ABP. Ref. 313361

Observation to Proposed SHD on Lands at Back Road & Kinsealy Lane, Kinsaley, Broomfield, Malahide, Co. Dublin

Submitted by: Lisa McKey, 16 Hazelbrook, Kinsealy Lane, Malahide, Co. Dublin. K36 CF96

23 May 2022

DRAWN PJD	DESIGNED RW	APPROVED MD	DATE NOV '20
SCALE 1:2000 @ A1	JOB NO. 18-091	DRG. NO. P100	REVISION A

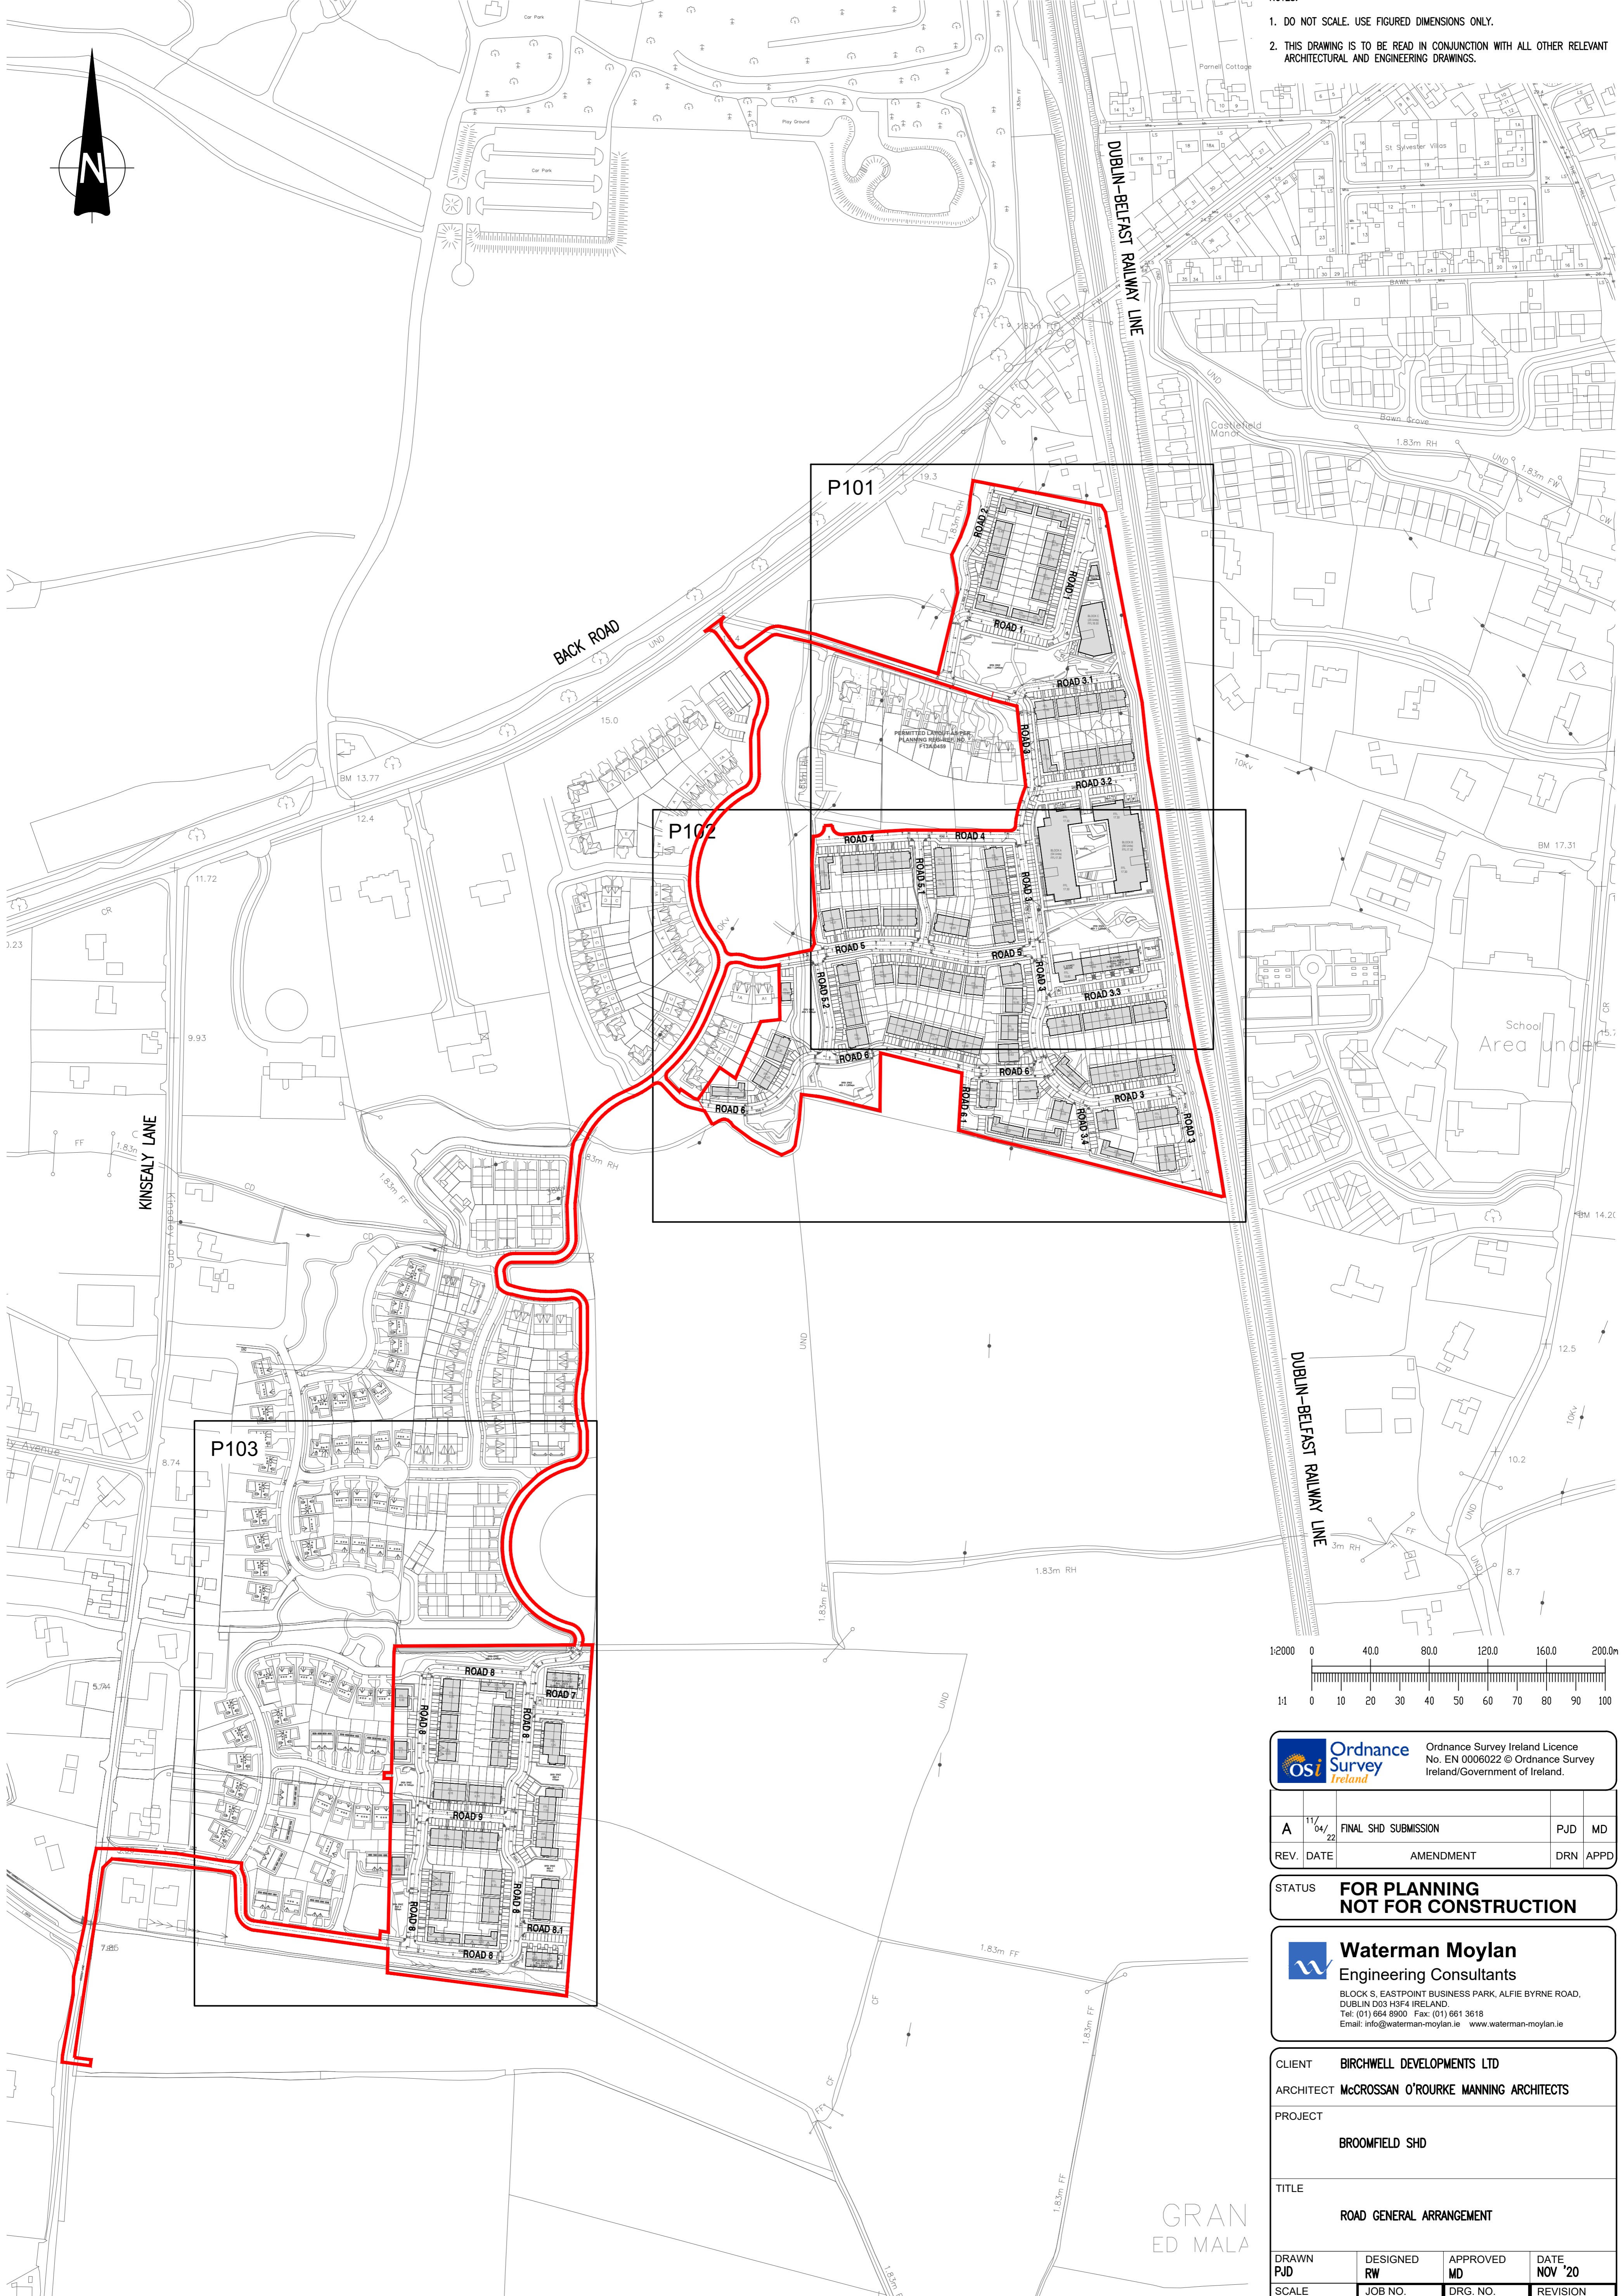
I have no objection to the further development of the proposed adjacent residential estate. I do have serious concerns regarding the proposed new road access to the Broomfield SHD and the "South Quarter" part of the site development.

The proposed through road (from Back Road to Kinsealy Lane) will lead to a significant increase in traffic. The number of Units proposed in this South Quarter will also significantly add to the volume of traffic. The road outside house number 26 to 29 is narrow. Cars are often parked on this road as their driveways do not cater for two cars, making it even more narrow.

At present, Kinsealy Lane does not have adequate footpaths or cycle paths, making it an unsafe lane to walk or cycle on. This Lane is already under significant pressure due to the number of cars driving up and down this lane. There would be a significant increase in traffic as a result of this proposed through road to Kinsealy Lane.

A more suitable direct traffic access onto Kinsealy Lane/Back Road is required,
